Technical Note

Project No: ITB14224
Project Title: Chalcroft Nursery
Title: Response to WSCC and HE Representations
Ref: ITB14224-011
Date: 24 September 2020

APPENDIX 3
SITE ACCESS PLAN (REF: ITB14224-GA-001 REV B)

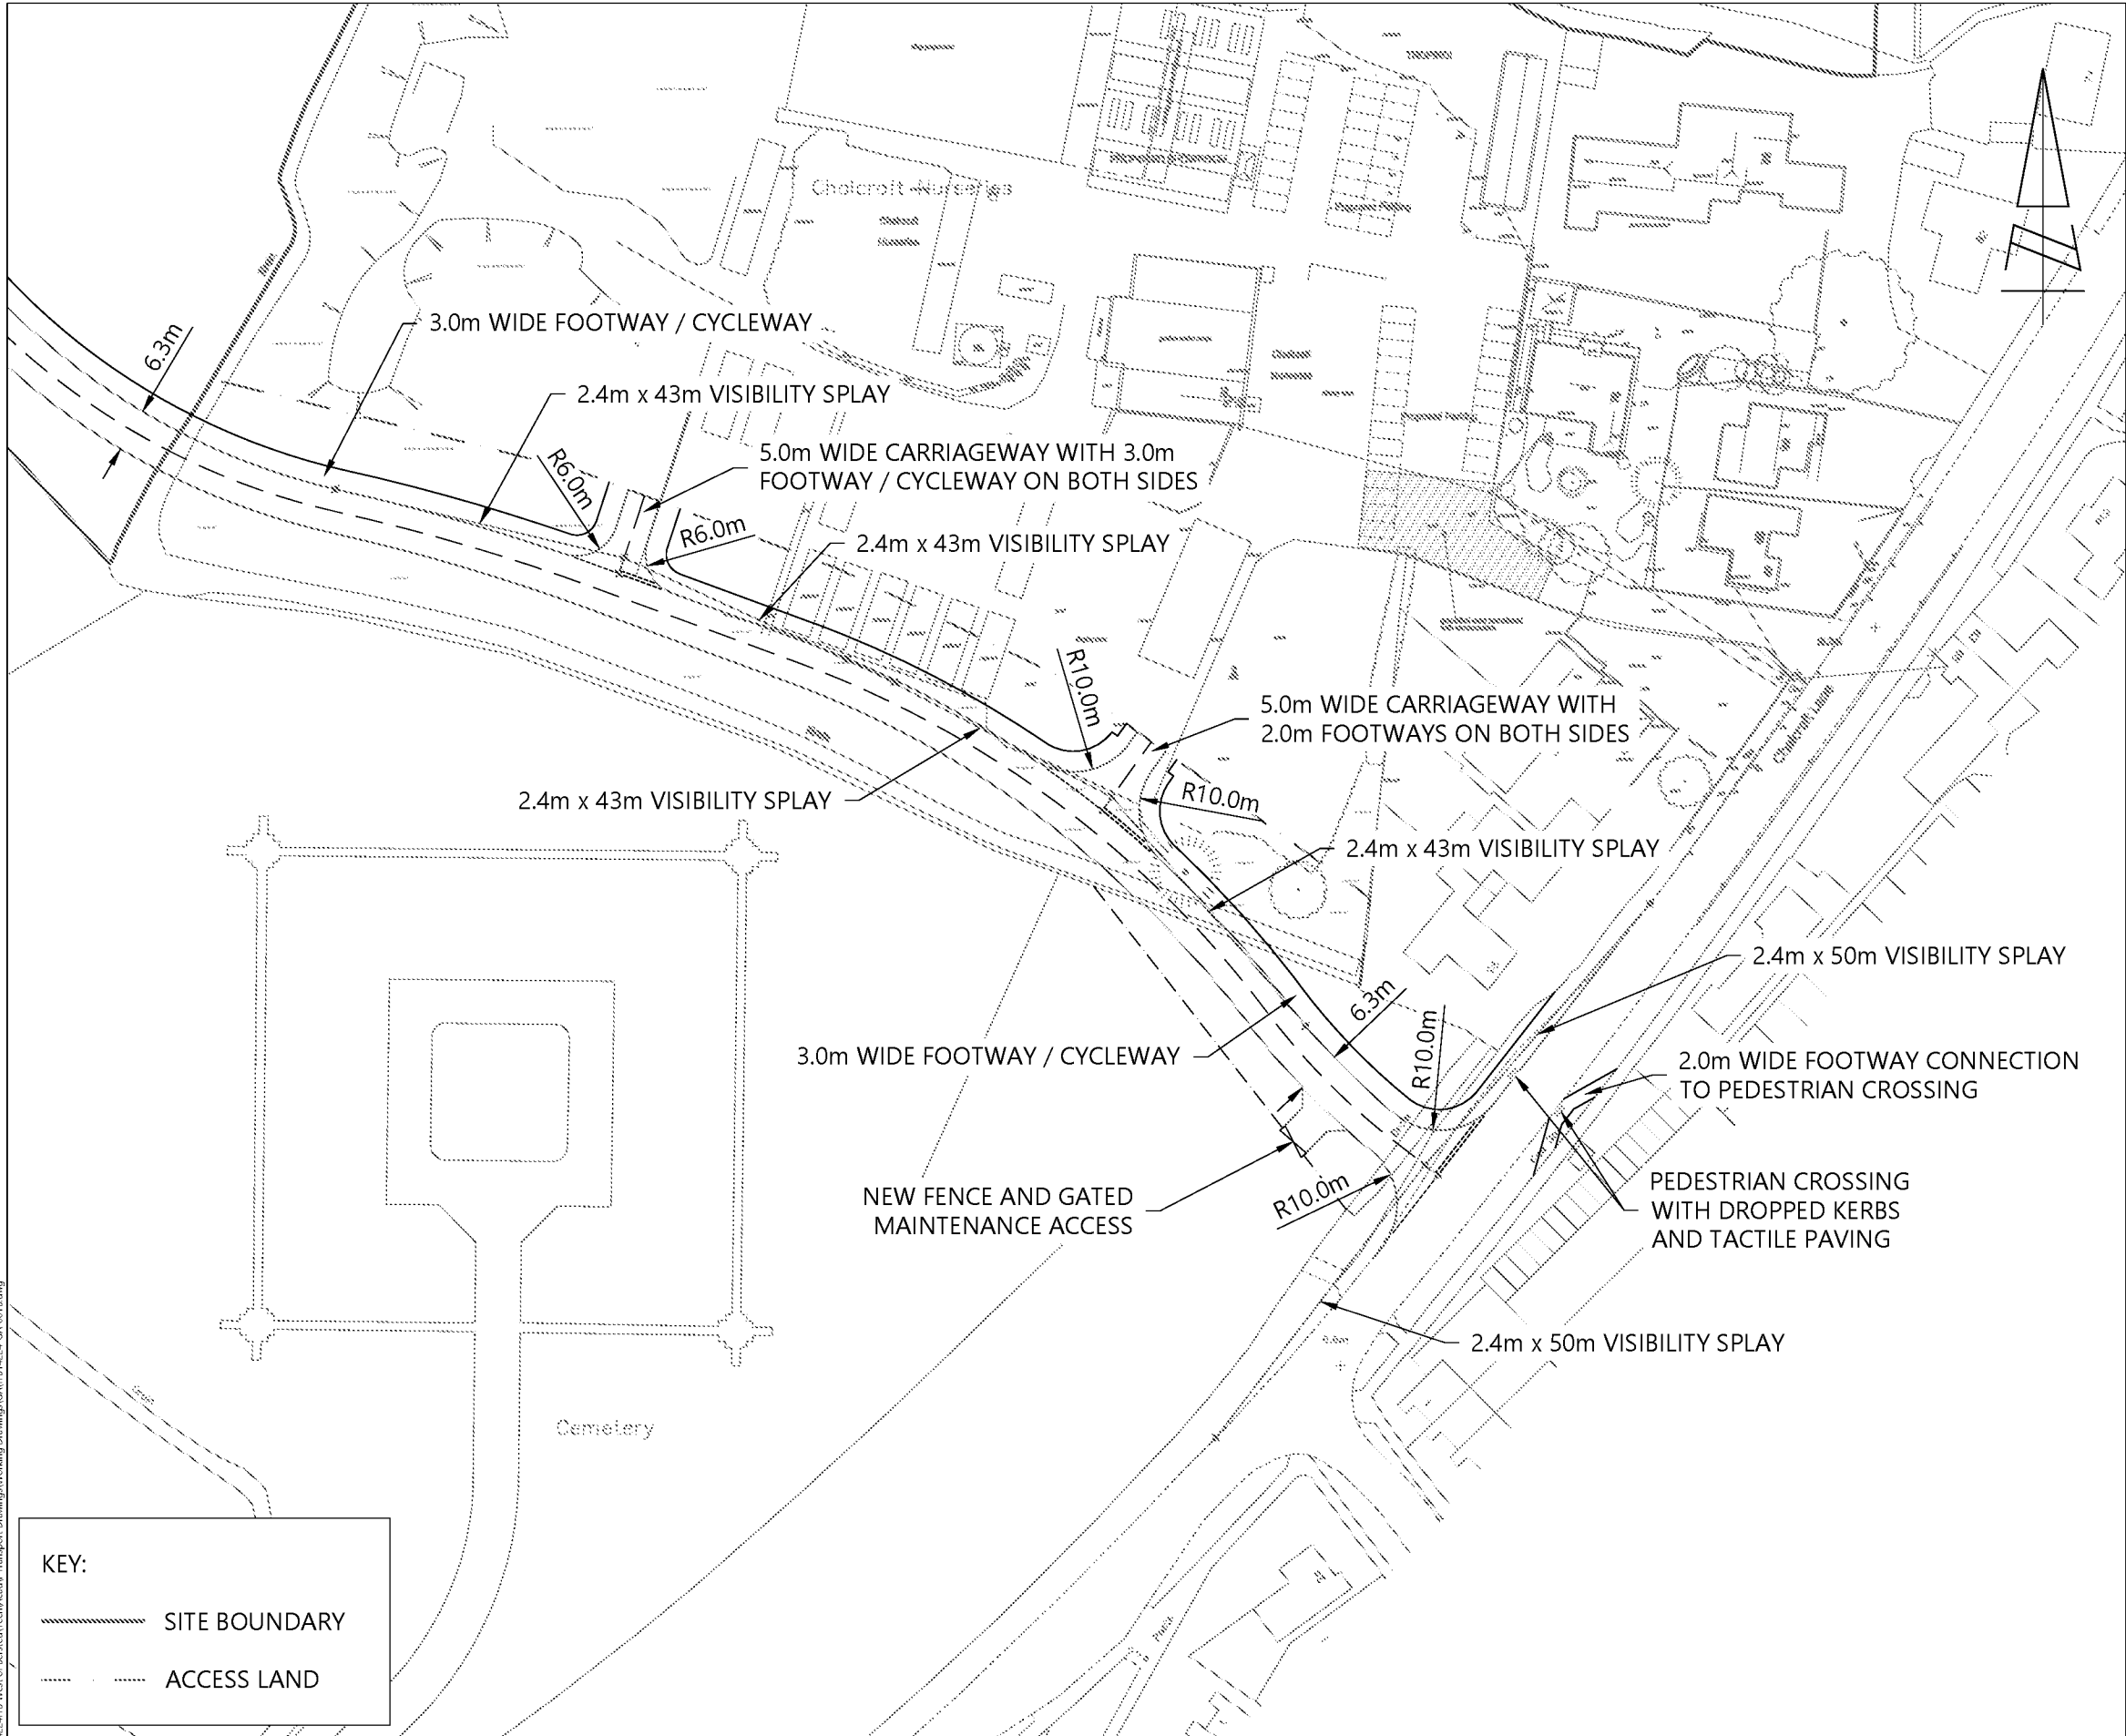
- 2.3.1 Local Transport Note 01/20 was released by the Government at the end of July 2020 and sets out guidance in respect of the provision and design for cycle infrastructure. Further consideration has been given to the guidance in respect of the proposed shared cycle route to the north of the access road.
- 2.3.2 Section 1.6 of LTN 01/20 identifies that (underlined for emphasis):

- 2.3.4 Paragraph 6.5.7 and Table 6.3 identifies that where pedestrian flows are up to 300 per hour, that a minimum shared-use width of 3.0m should be provided. Further, Table 5.3 identifies that where a kerb between 61mm and 150mm in height is present then a further 200mm should be provided to maintain effective width of the cycle track.

- 2.3.5 Therefore, as a kerb is present on one side of the path, the design has been amended to provide a route with a width of 3.2m. The revised arrangement is presented in Drawing ITB14224-001 Rev D.

- 2.4.4 To the south of the site, the route is currently shown as terminating on Chalcraft Lane. It is recognised that to support the connectivity aspirations, that as part of any development proposals for the wider site connectivity will need to be provided through to Central Drive. However, it would not be appropriate to form through links as part of this development as a) with reference to the tests on the

2.4.5 As such, the design has been amended to incorporate interim measures to enable cyclists to leave and join the access road carriageway. This includes a short section of cycleway on the southern side of the carriageway to enable cyclists to exit the carriageway and cross, and a dropped kerb on the northern side of the carriageway with demarcation to enable cyclists to join the carriageway prior to entering Chalcroft Lane. Additionally, the 'end of route' demarcation has been relocated to the access road.
